THE PURPOSE OF THIS ADDENDUM IS TO ADD PARCEL 5Z. CHANGED PUE TO DUE ON PARCEL 5Z. REMOVED TCE AND RW ON PARCEL 11. ELIMINATED PARCEL 11.

PROJECT REFERENCE NO. R-5819R-5820	SHEET NO. RW13A
Location and Surveys	
NC DOT LOCATION AND SURVEYS DIVISION 6 FIELD OFFICE	
PROJECT SURVEYOR 	
DOCUMENT NOT CONSIDERED FINAL UNLESS ALL SIGNATURES COMPLETED

PROJECT REFERENCE NO. R-5819R-5820	SHEET NO. RW13
Location and Surveys	
NIV5	
<small>NIV5 ENGINEERS & CONSULTANTS, INC. 3300 REGENCY PARKWAY, SUITE 100 CARY, NC 27518 P: 919.851.1912 www.NIV5.com</small>	
PROJECT SURVEYOR	
DOCUMENT NOT CONSIDERED FINAL UNLESS ALL SIGNATURES COMPLETED

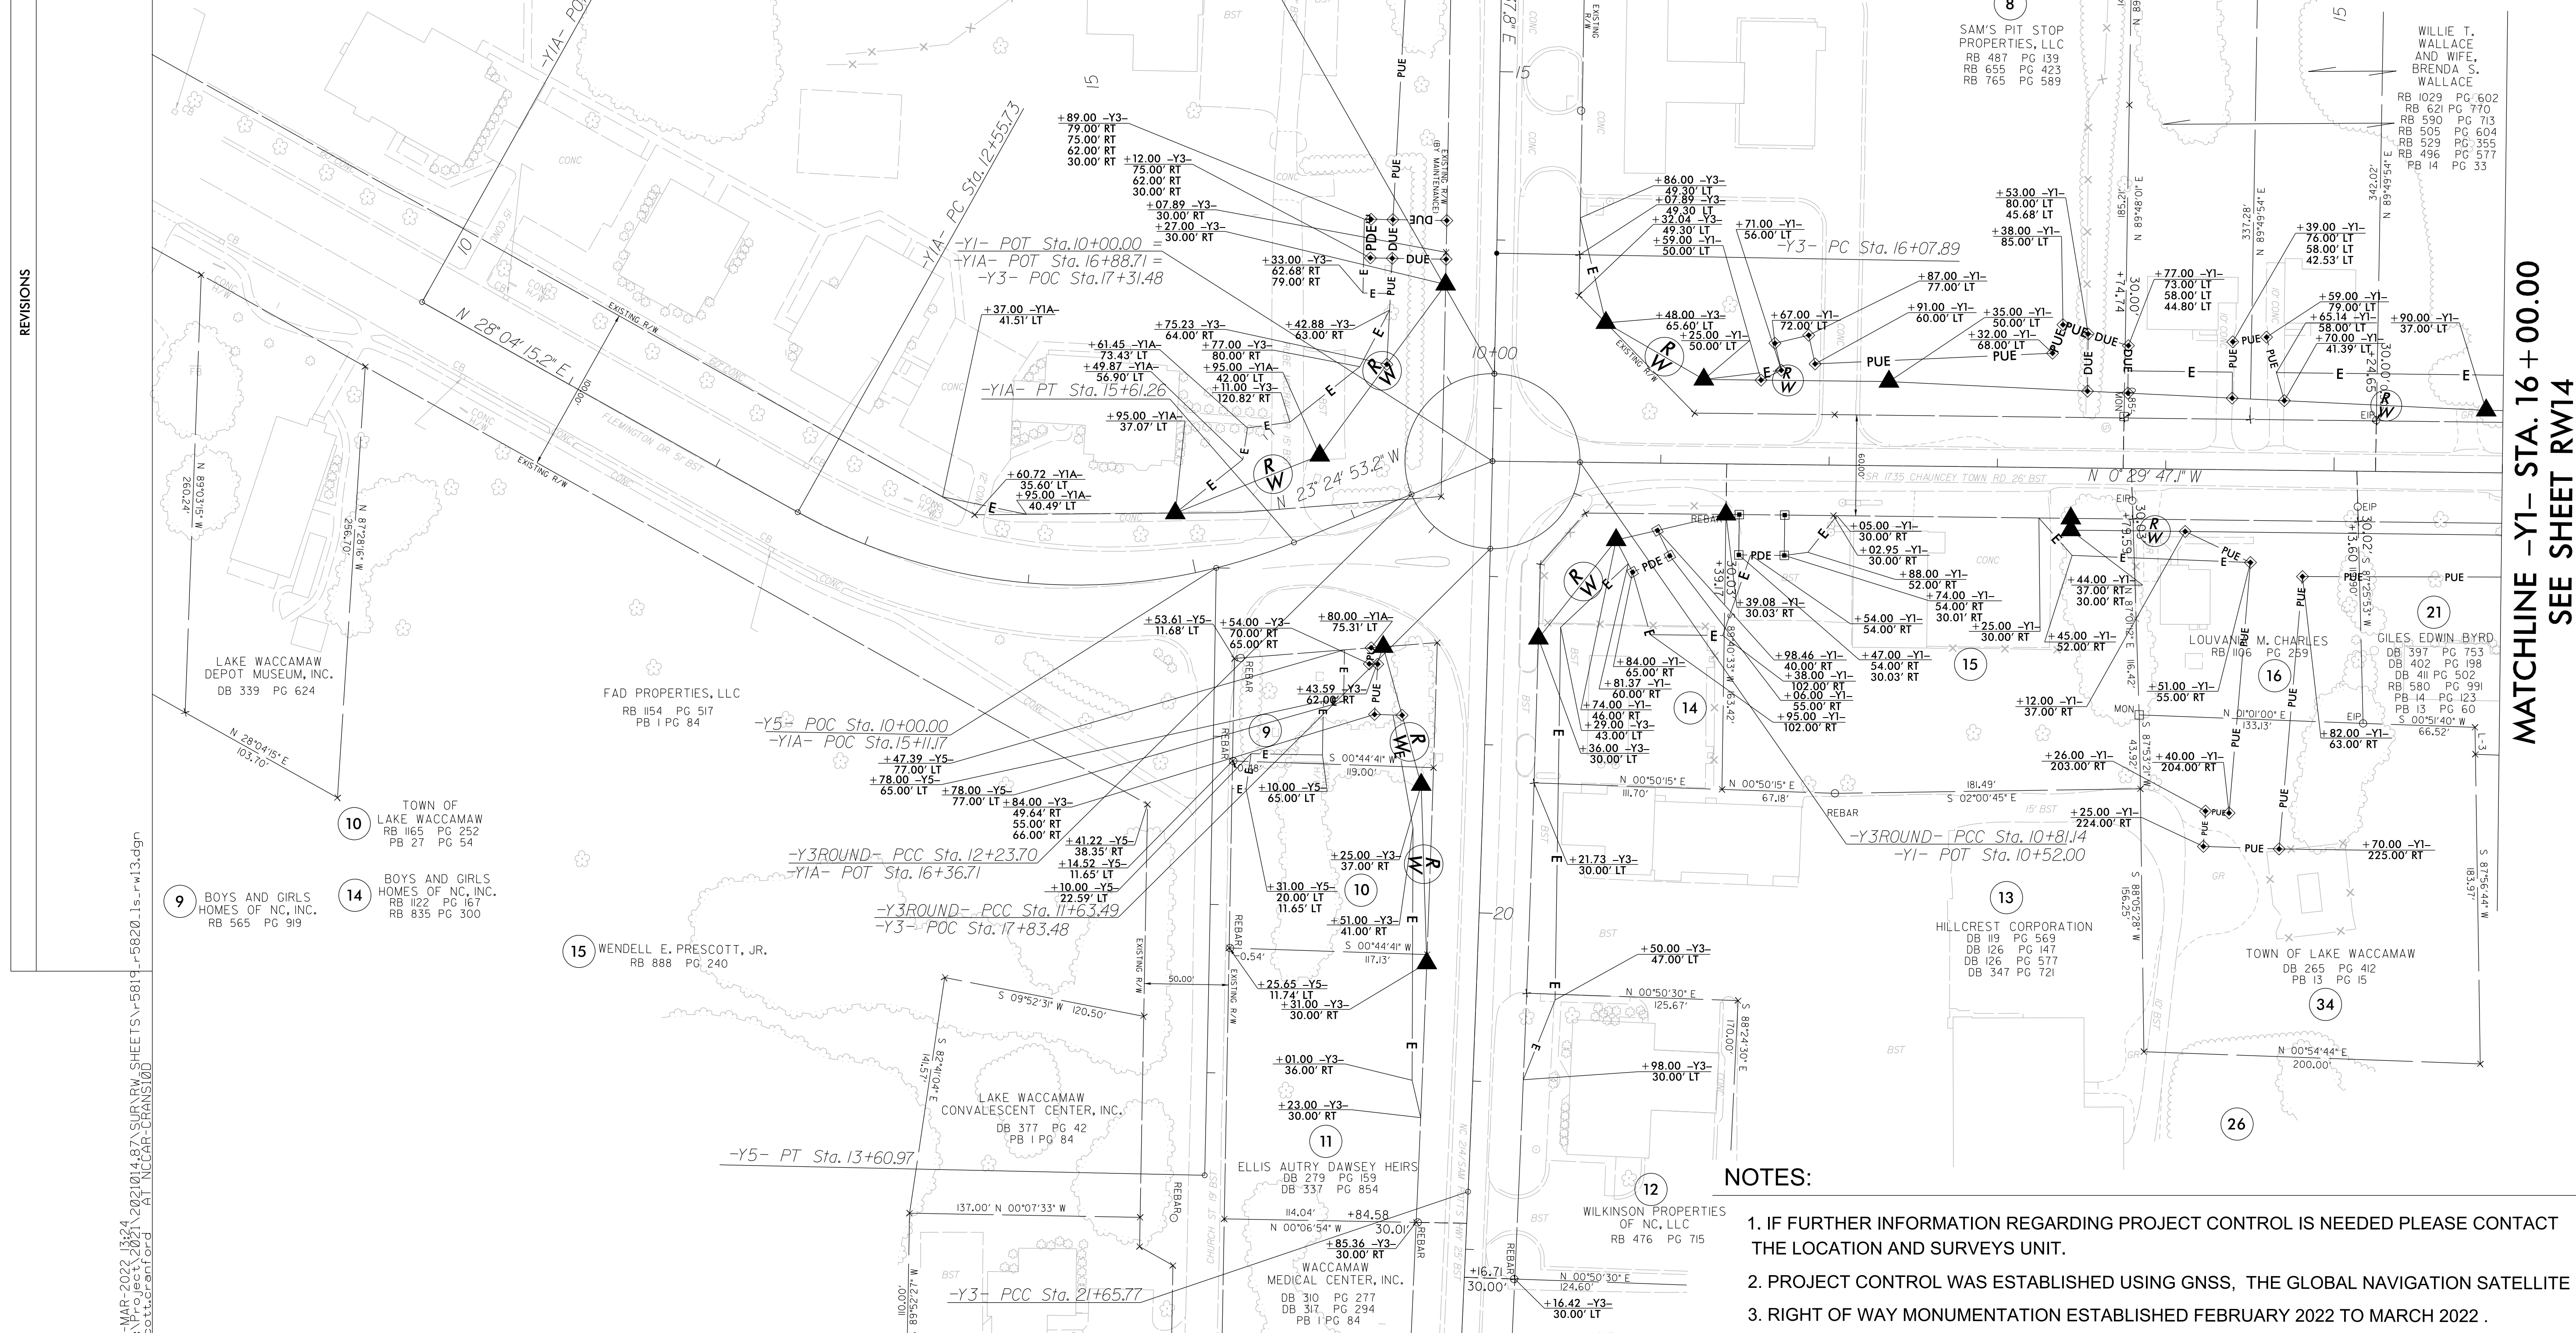
ADDED PARCEL 5Z. CHANGED PUE TO DUE ON PARCEL 5Z.

REMOVED TCE AND RW ON PARCEL 11. ELIMINATED PARCEL 11.
